Council Reference: DA10/0222.24 LN44549
Your Reference: MP06_0258 MOD 8

10 September 2014

**Development Application DA10/0222.24 - amendment to
Development Consent DA10/0222 for Casuarina Town Centre
including 56 lot subdivision, road works, infrastructure works
and landscaping (Department of Planning Application
MP06_0258 MOD 8) at Lot 13 DP 1014470; Casuarina Way
CASUARINA; Lot 144 DP 1030322 & Lot 144 DP 1030322 & Lot
3 DP 1042119; Tweed Coast Road CASUARINA**

Building Signage Details
DA14
PA-4

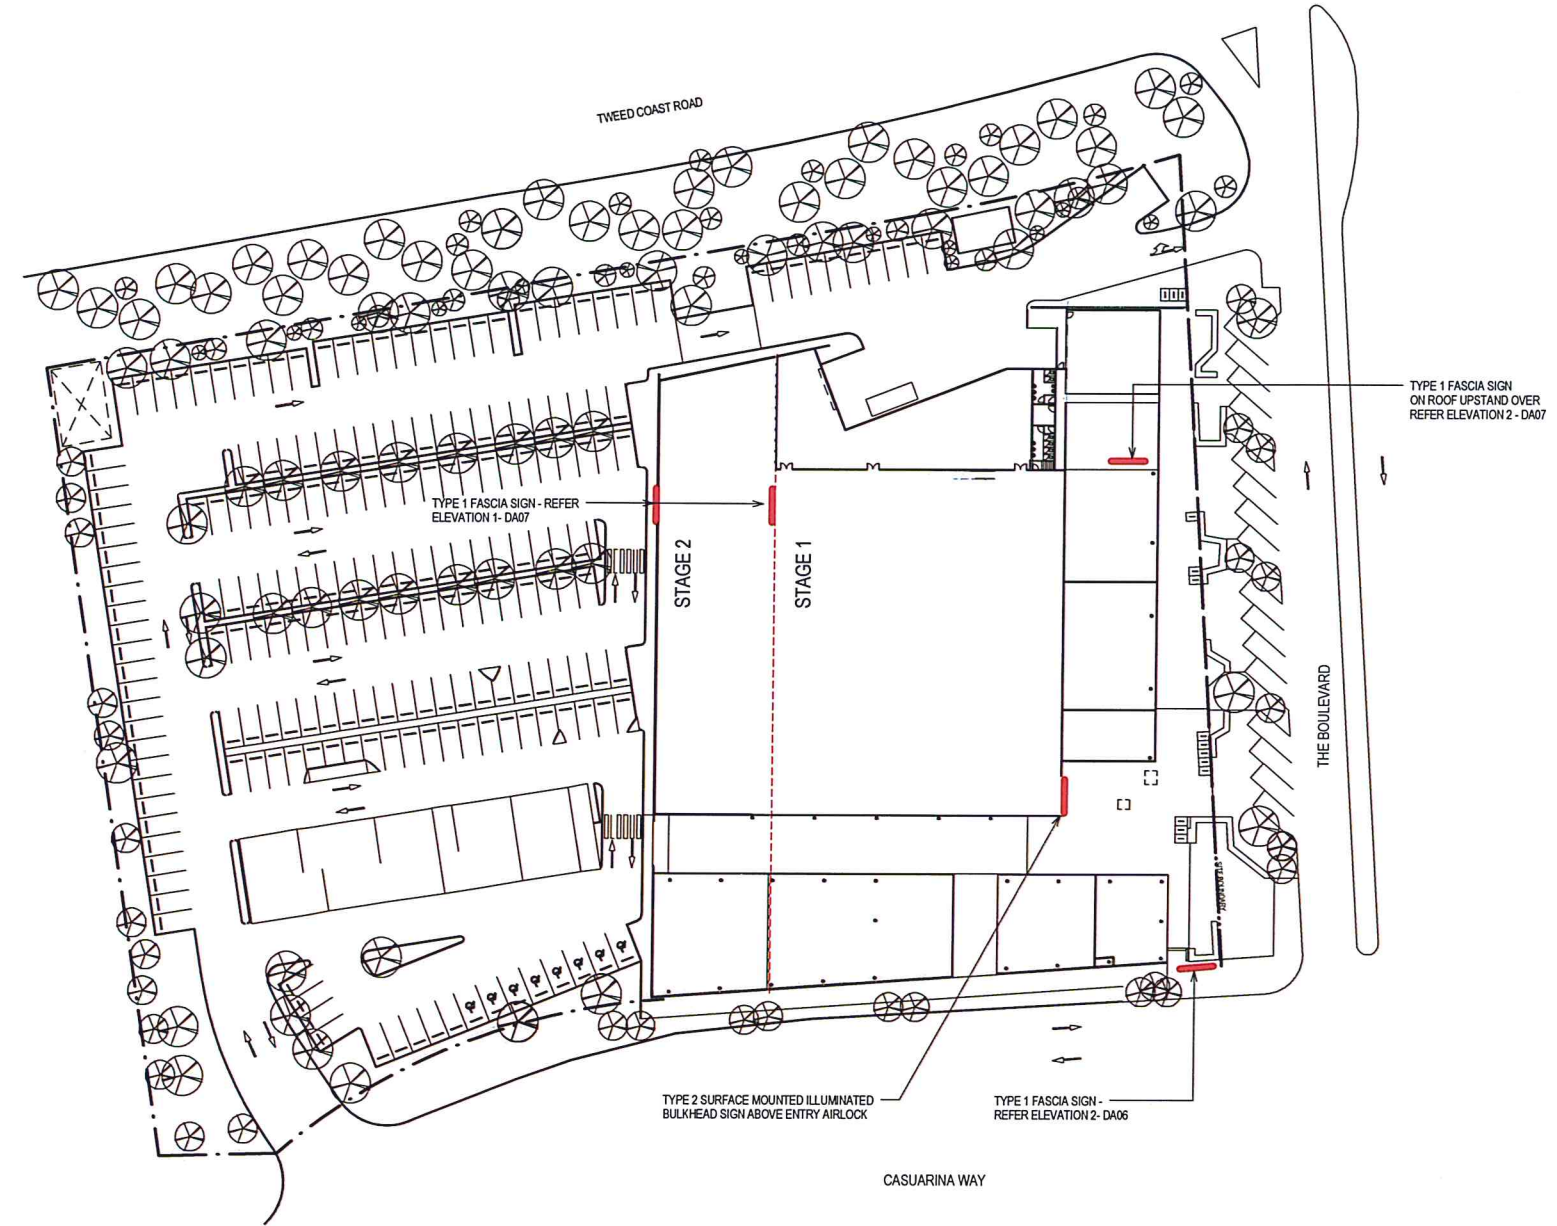
It is noted that an illuminated 12m high pylon sign is proposed to the north-west corner of the site, adjacent to the Tweed Coast Road/Grand Parade (identified on submitted plans as Main Street) intersection. Tweed Coast Road is a classified road and therefore may require concurrence from the Roads and Maritime Services (RMS) under the provisions of State Environmental Planning Policy No. 64—Advertising and Signage, Clause 18, depending on the area of the advertisement (detailed design has not been provided in relation to the pylon sign).

It is further noted that the proposed sign would require assessment under the provisions of State Environmental Planning Policy (Infrastructure) 2007, which also outlines criteria for development with frontage to classified roads under Clause 101.

The subject modification has also been reviewed by Council's Traffic Engineer who recommended that the assessment authority consults with the Roads and Maritime Services with respect to determining if there are any potential conflicts between the proposed illuminated pylon sign and regulatory traffic controls at the Tweed Coast Road/Grand Parade intersection.
